Please see the email below from Sam Sykes at ECE Planning regarding planning application **WA/59/20/PL** relating to Land East of Tye Lane, Walberton.

From: Sam Sykes [REDACTED]
Sent: 04 November 2020 12:25
To: Michael Eastham <Michael.Eastham@arun.gov.uk>
Cc: John Longhorn [REDACTED]; Amy Savage [REDACTED]; Chris Barker [REDACTED]; Nick Francis [REDACTED]
Subject: P1728 EMAIL ECE Planning Streetscene Suggested Amendments / Open Space 201104

Subject: RE: WA/59/20/PL Land East Of Tye Lane Walberton; ECE Planning Streetscene Suggested Amendments 201026

Plots: 23-24, 25-26

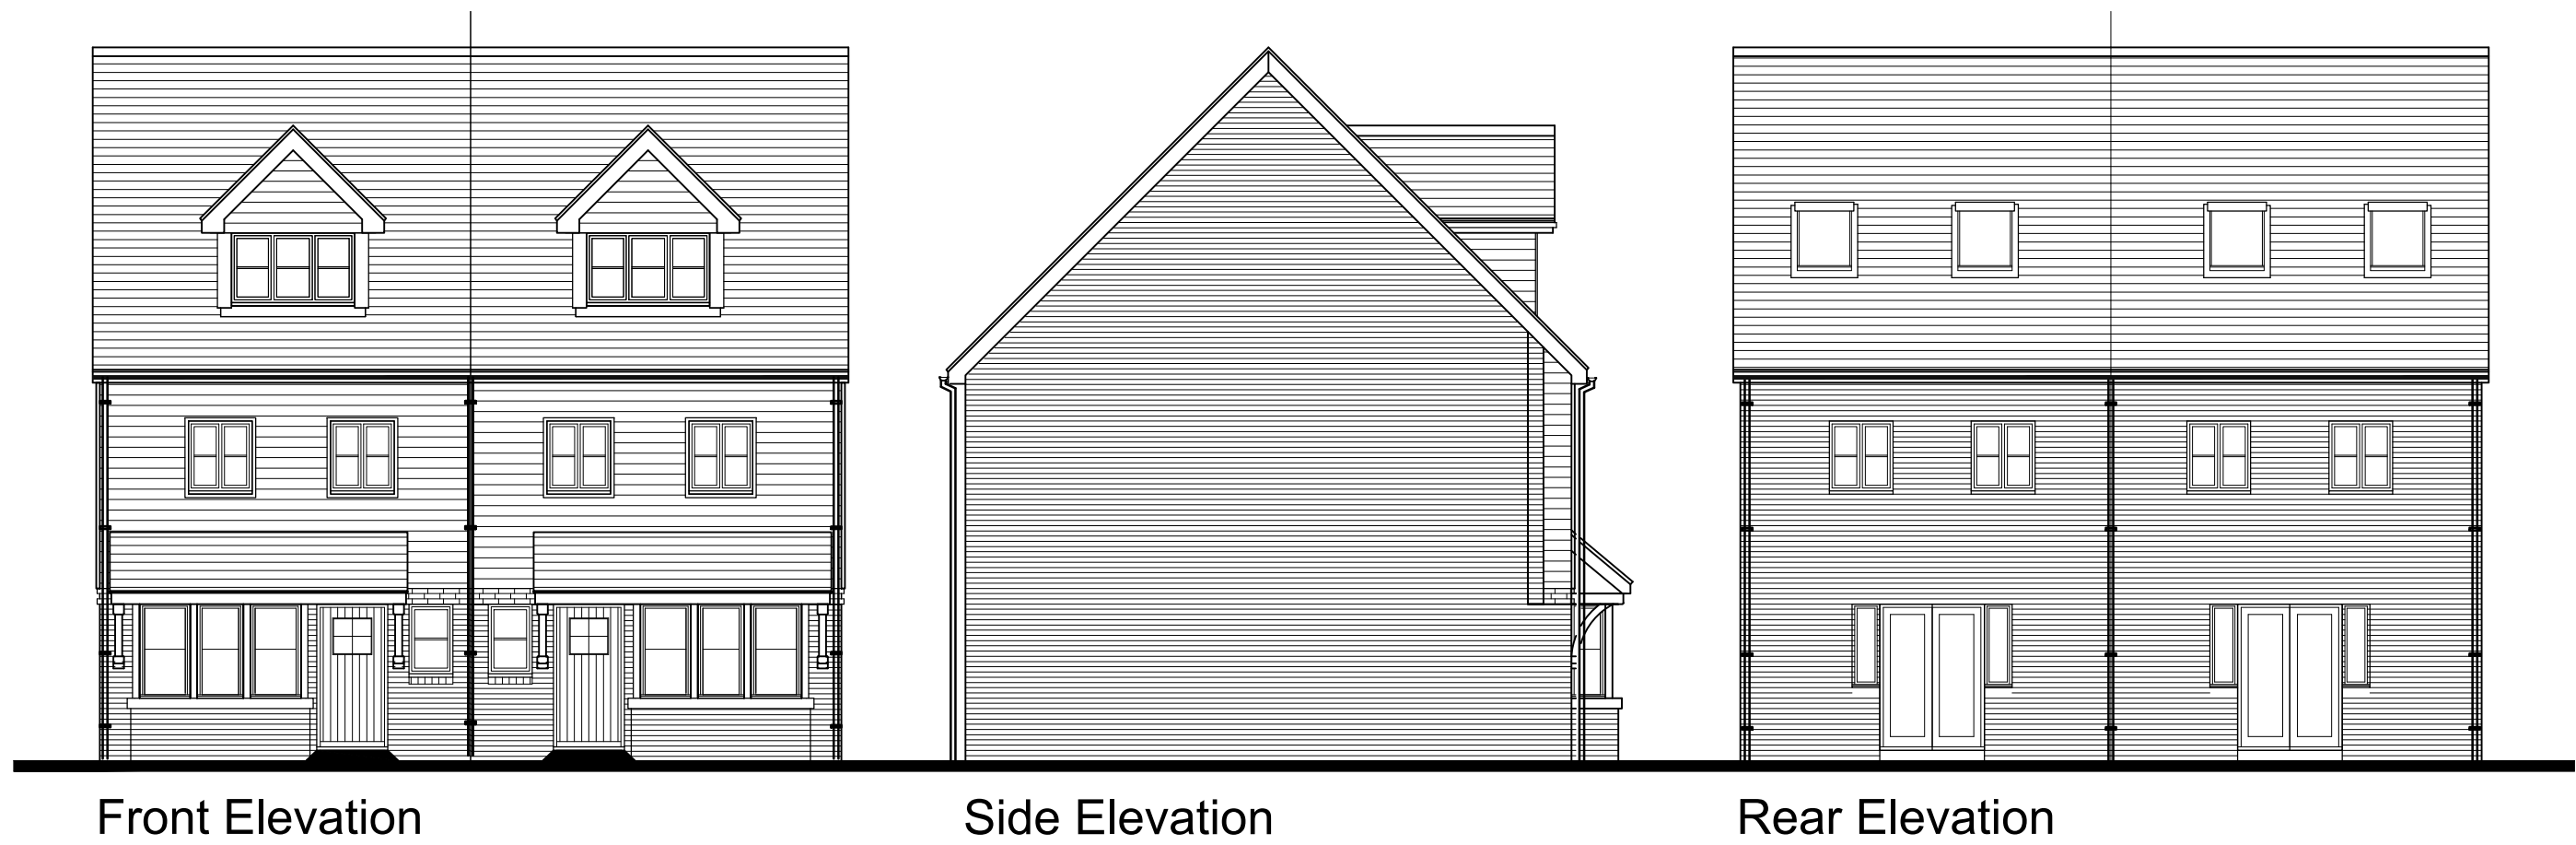
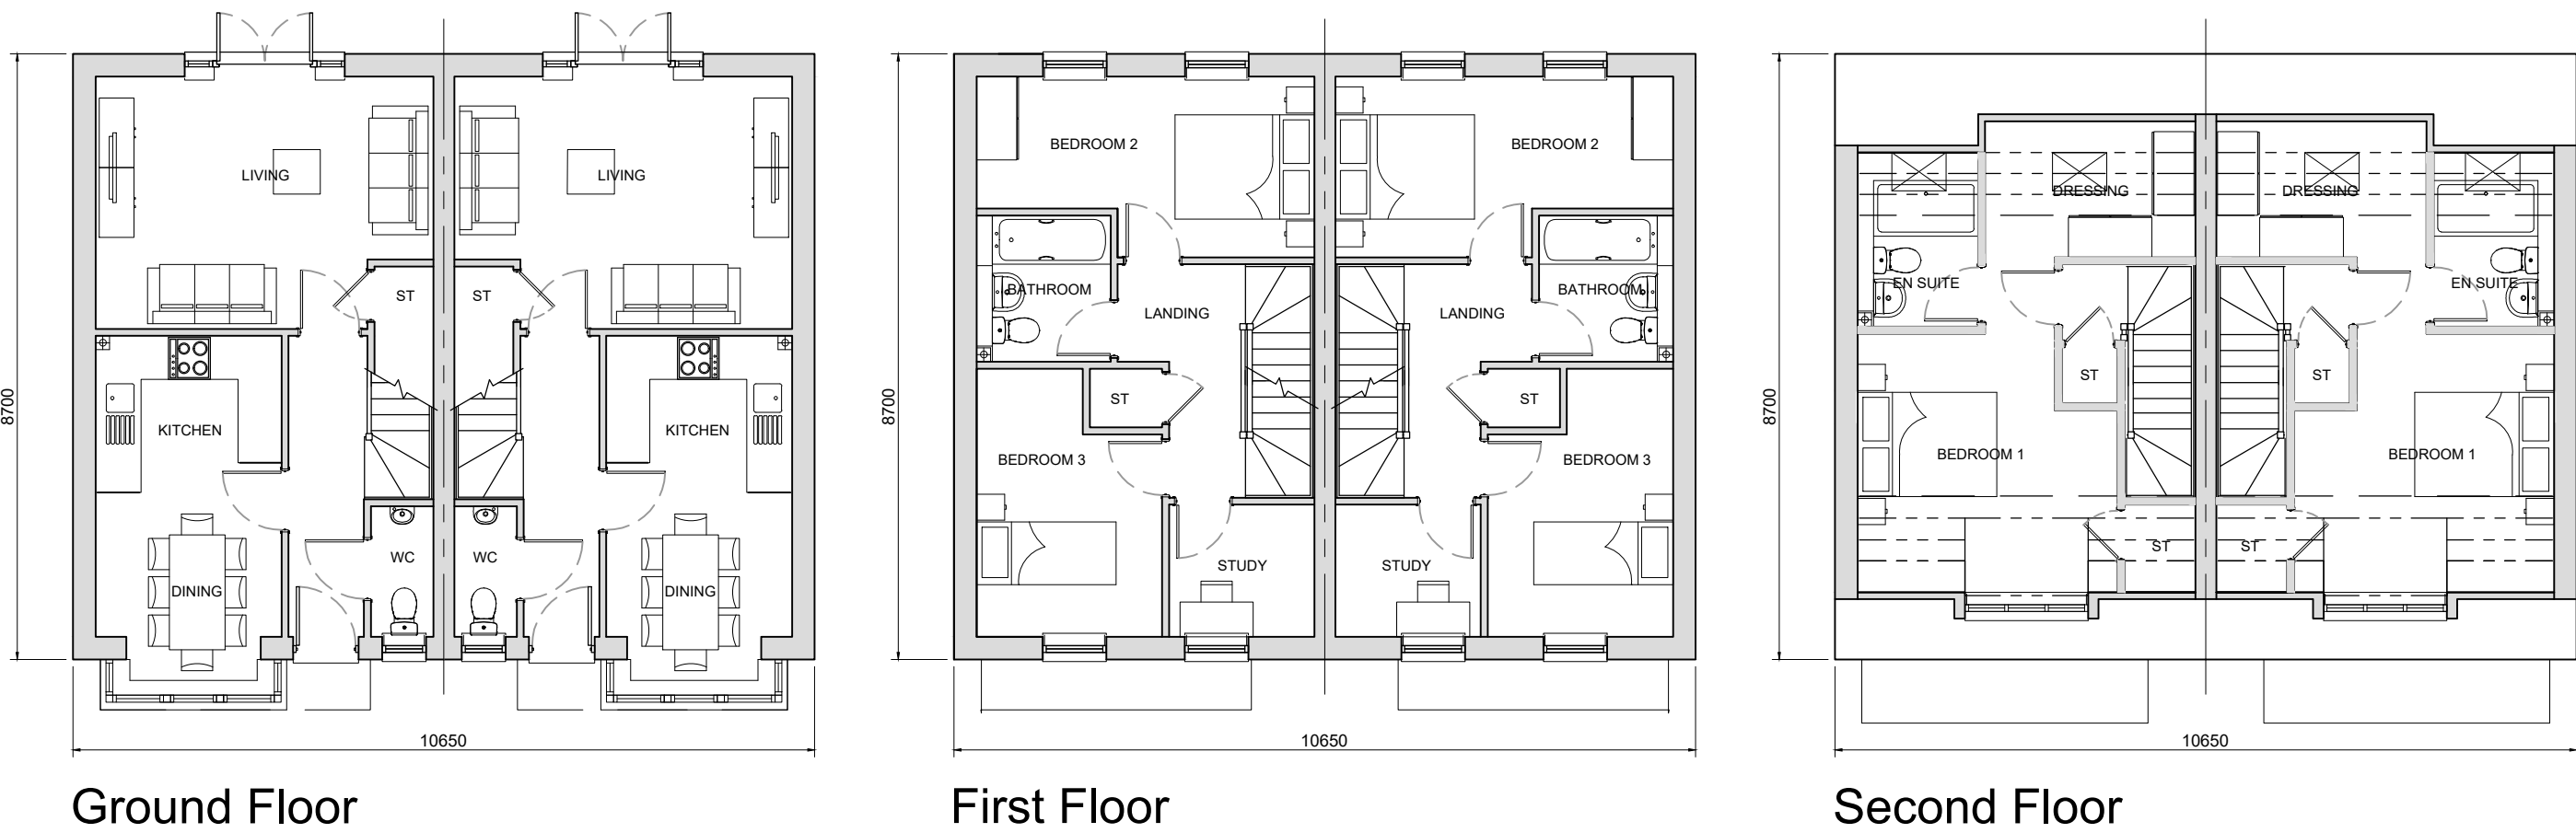
Thank you for your two emails with further suggested design changes. We are confident that we can accommodate all of your amendments except for the suggested change which relates to the 4 x 2.5 storey dwellings (units 23 to 26).

You will note that in our amended street scenes we lost a pair of these taller units reducing the run of these dwellings from six down to four. We retained units 23 to 26 as previously shown (albeit with more contemporary dormers) as we felt that these units were well placed within the Avenue character area as the least sensitive positioning from a visual / character perspective. We lost a pair of these units however to break up the street scene following our pre app discussion but retained the four units as shown as we also felt these framed the termination of the road to the north. Regardless we do not consider the retention of these units to be harmful in character terms.

Notwithstanding this position, Vistry is very concerned about the impact on values of losing more of these units (which are the most popular house type in the Vistry range). Given the uncertainty and immediate impact that the A27 route announcement is having on sales and interest in new units Vistry would like to retain these units.

Could the housetypes on Plots 11 and 12 be used again in place of the current house types on Plots 23, 24, 25 & 26 shown below ,with the hipped roofs on Plots 23 and 26; and the number of semi-detached units be reduced in the long row from Plots 21 to 28 inclusive:
